October 19, 2023

RE: Fowler Creek Guest Ranch (CU-23-00003)
Applicant: Fowler Creek Trails, LLC (Owner)

1. INTRODUCTION

EXHIBIT 16 - SITE PLAN - FOWLER CREEK GUEST RANCH

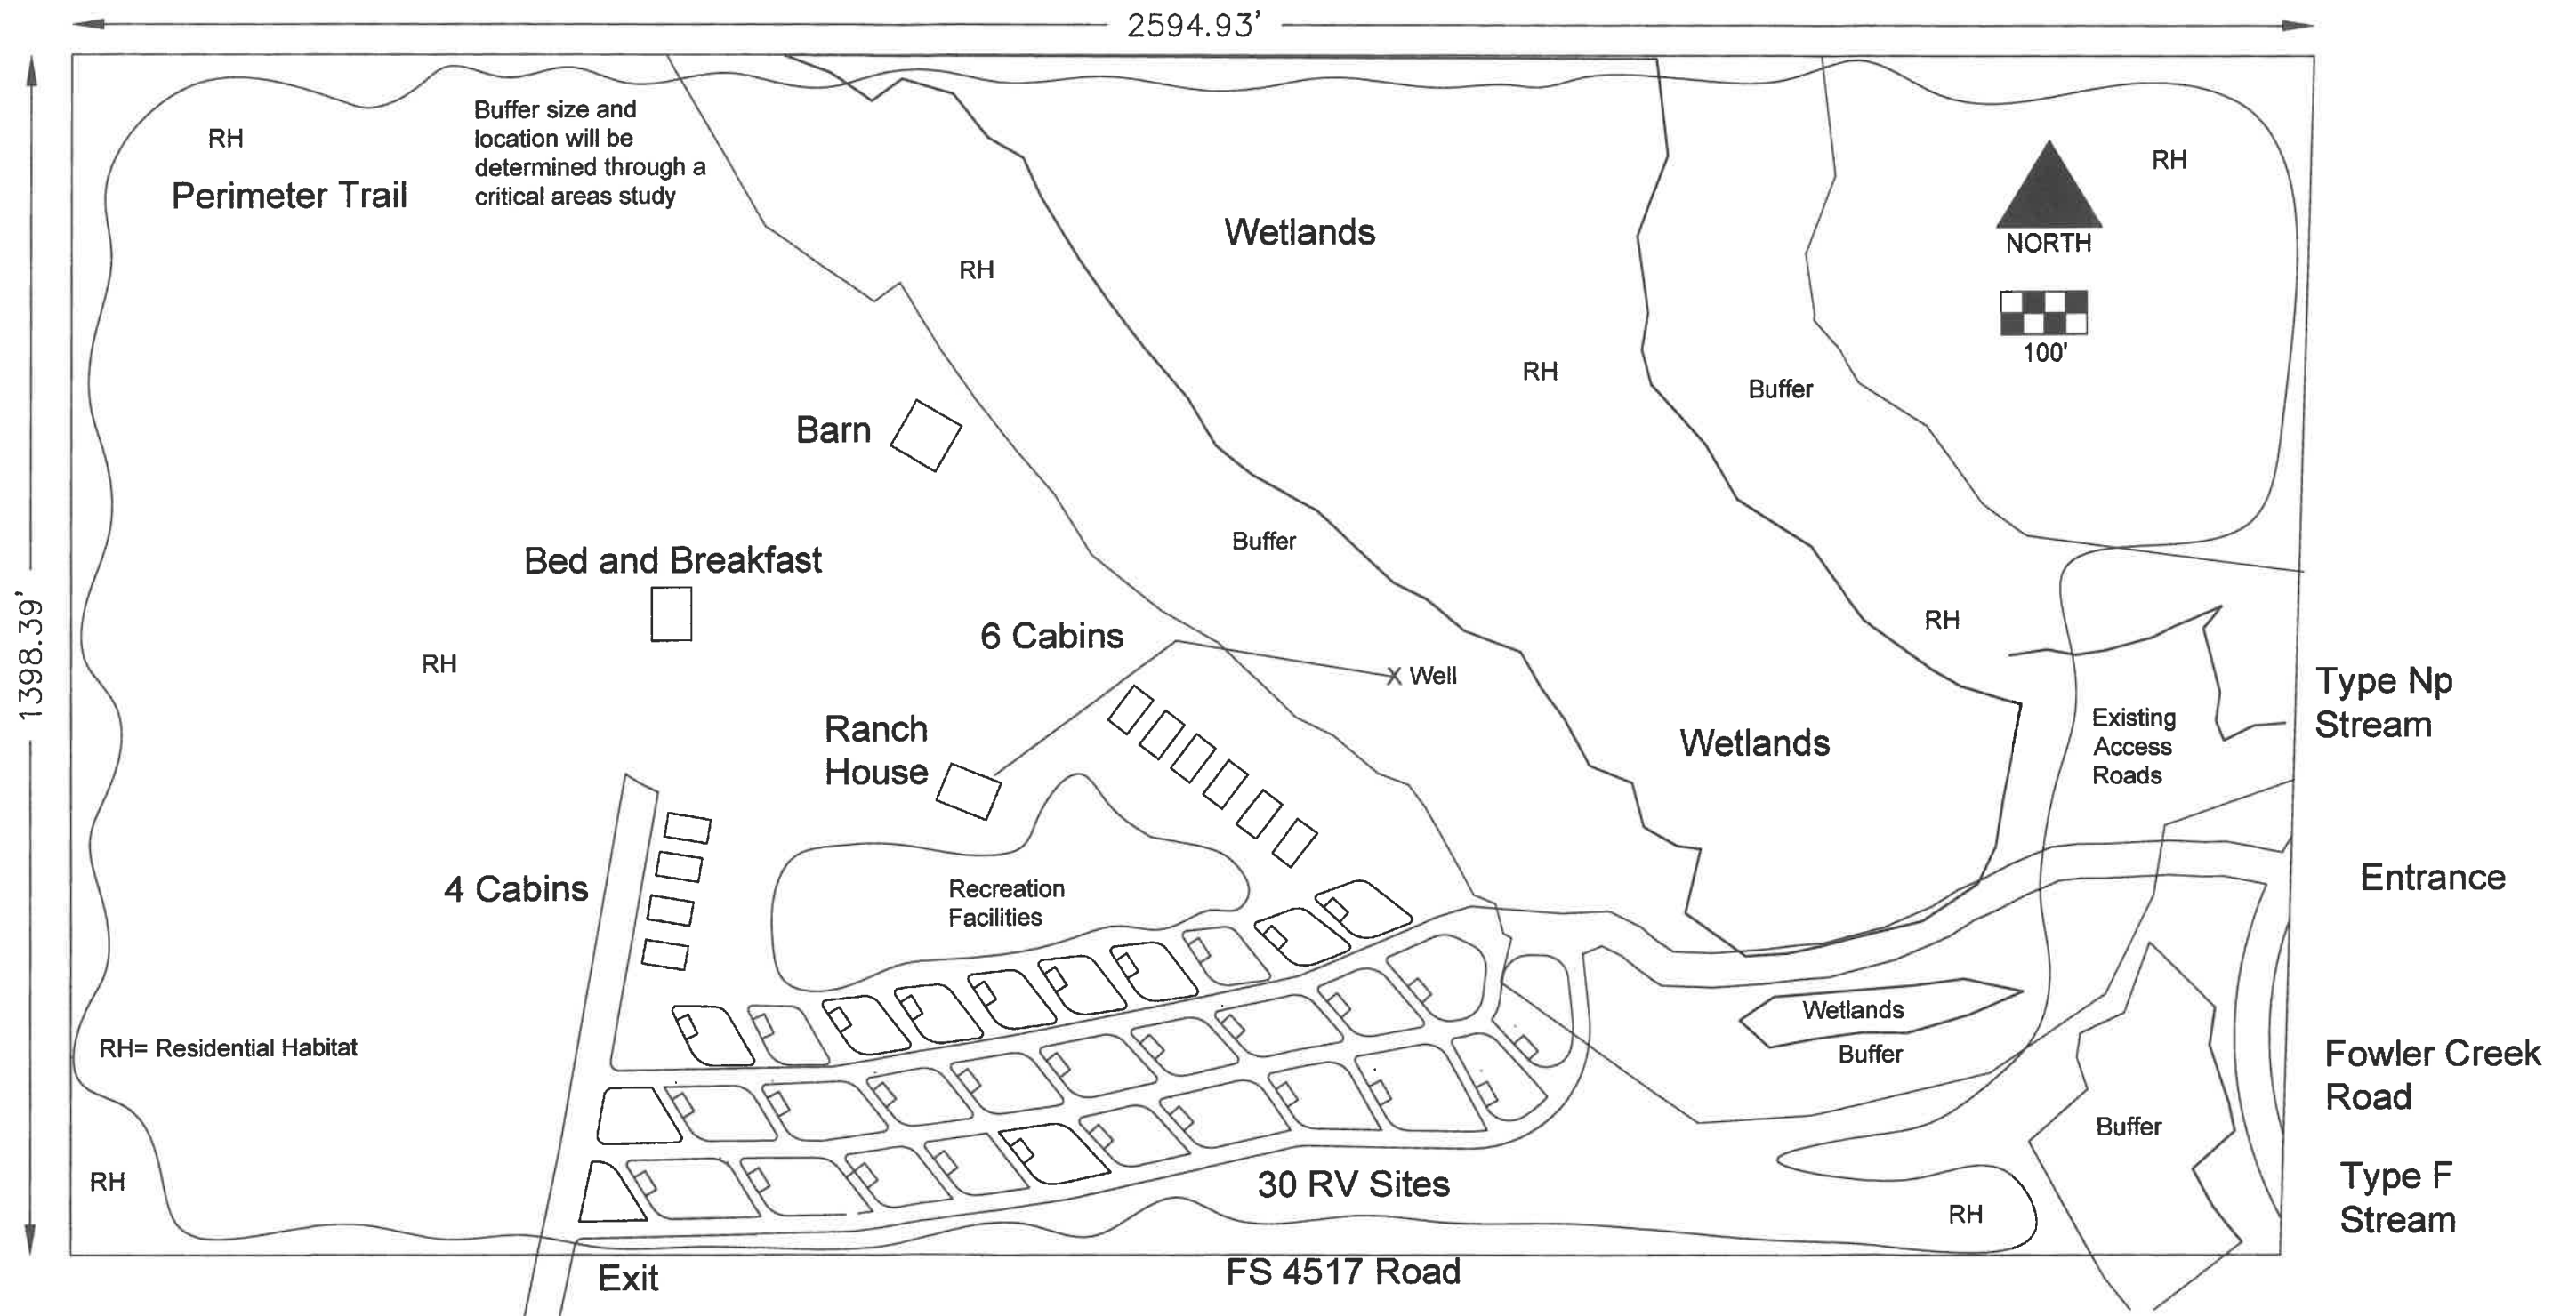
The present application is not supported by information from a qualified professional. Its “site plan” is not dimensioned based on an underlying survey. There has been no on the ground wetlands delineation. There is an inchoate proposal, though, for which approval is sought in the CUP application, to place overnight lodgings in the wetlands or buffers. This neither satisfies Code critical area requirements nor mandatory Code CUP criteria.
